REVISION RESPONSE LETTER

**RE: National Mill Dog
Site Development Plan
File Number: PPR-1937**

DATE: October 18, 2019

1 SITE PLAN  
SCALE: 1"=30'-0"

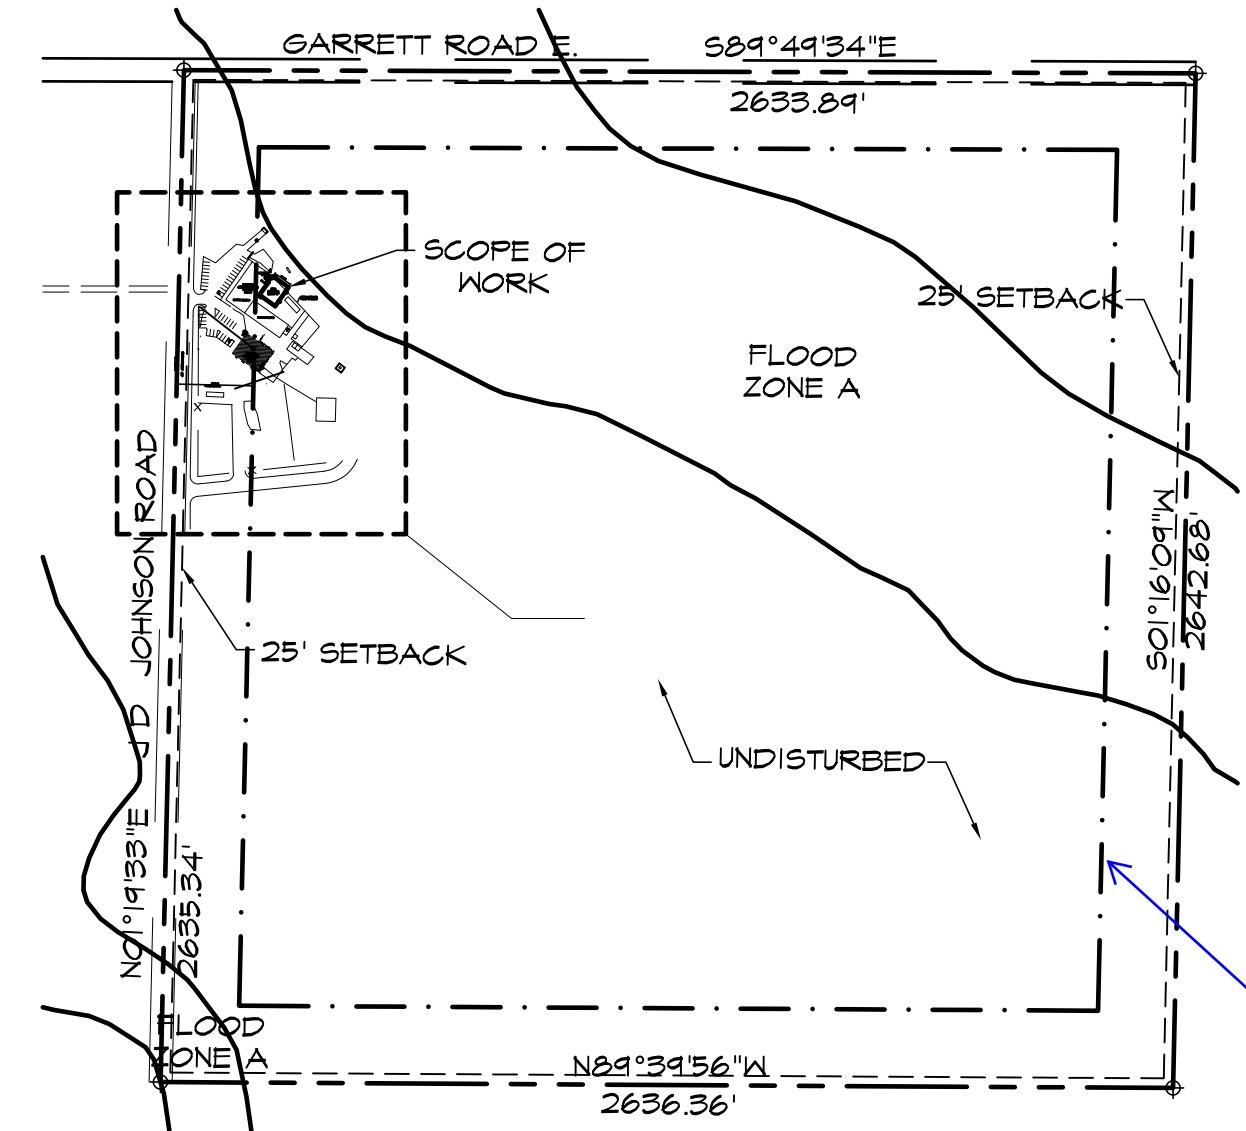
1. *Please label all of the smaller existing structures shown on the site plan and/or aerial.*
Updated – Labeled all smaller existing structures on site plan.

5. *Footnote 7 of Table 5-4 indicates that kennels shall be setback a minimum of 200 feet from all property line to new kennel building to demonstrate compliance with that requirement. Noted. We are 212'-4" away from property line. (dimension shown on site plan)*
